Response to Submissions Report

SSD-9575-Mod-2: Modification to New Tweed Valley Hospital

Prepared for: Health Infrastructure
© GeoLINK, 2020

**SOUTH-EAST ELEVATION - CAR PARK**  
SCALE 1:2000

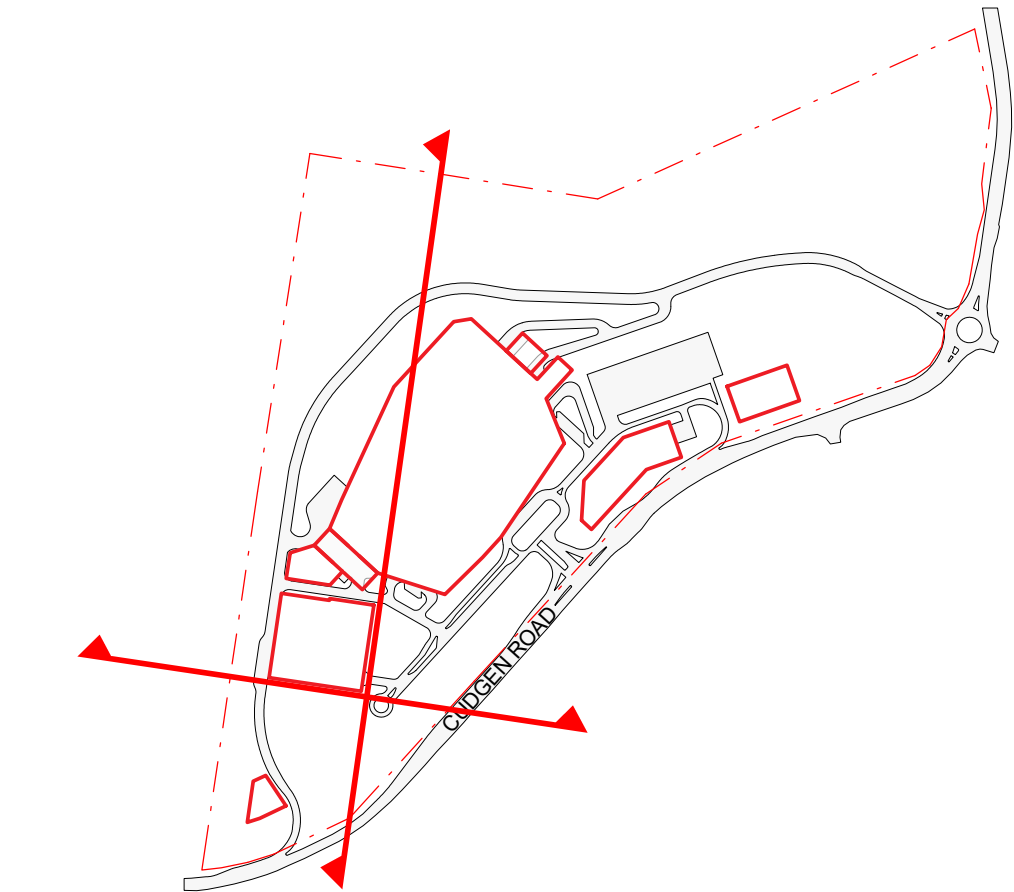
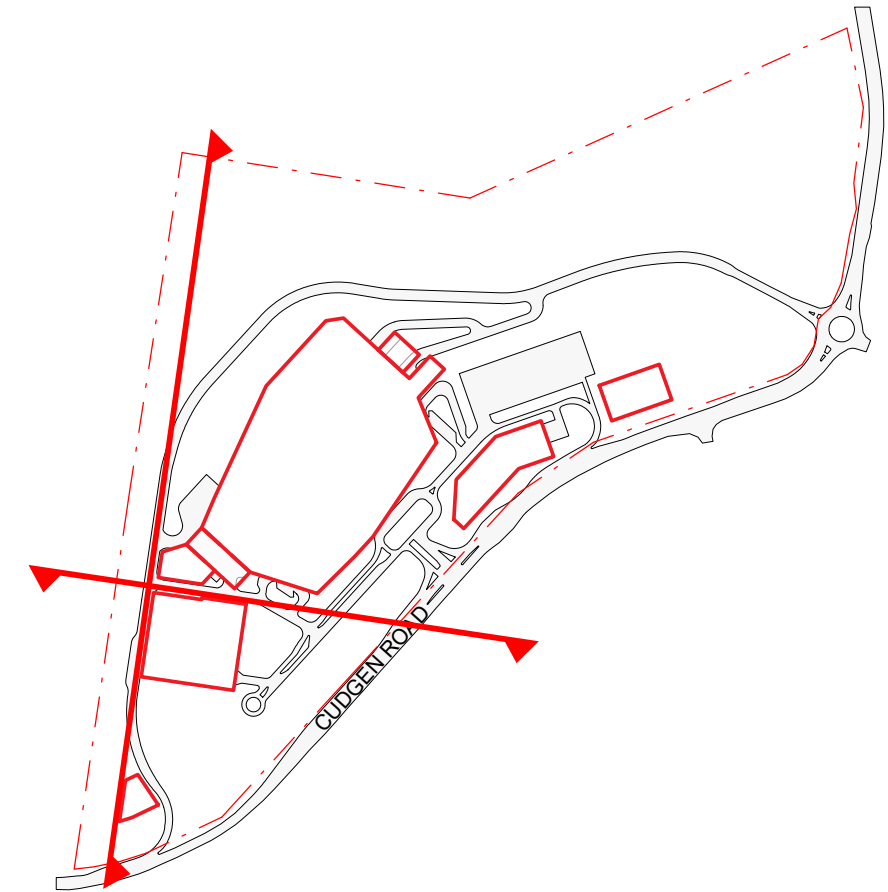
The visual impact of the 10-storey car park has not been considered. It will be visible from all parts of the Valley. The images are misleading, as the 10-storey car park is lower than the hospital building in architectural renders.

An independent Visual Impact Assessment (VIA) was undertaken by Urbaine, attached to the EIS as Appendix J. The visual impact of the multi-deck car park envelope was assessed in Section 5.3.3 of the Modification Report, and the supporting VIA, however an updated report has been prepared, and is attached to the Response to Submissions as **Appendix D**. The updated report includes renders outlining the visual impact of the multi-deck car park.

Despite being 10 levels, the car park's comparative low floor to floor level ensures the structure remains low in height adjacent to the main hospital envelope, adding minimal additional low-level mass to the visible bulk of the development, including when viewed from the local vantage positions studied.
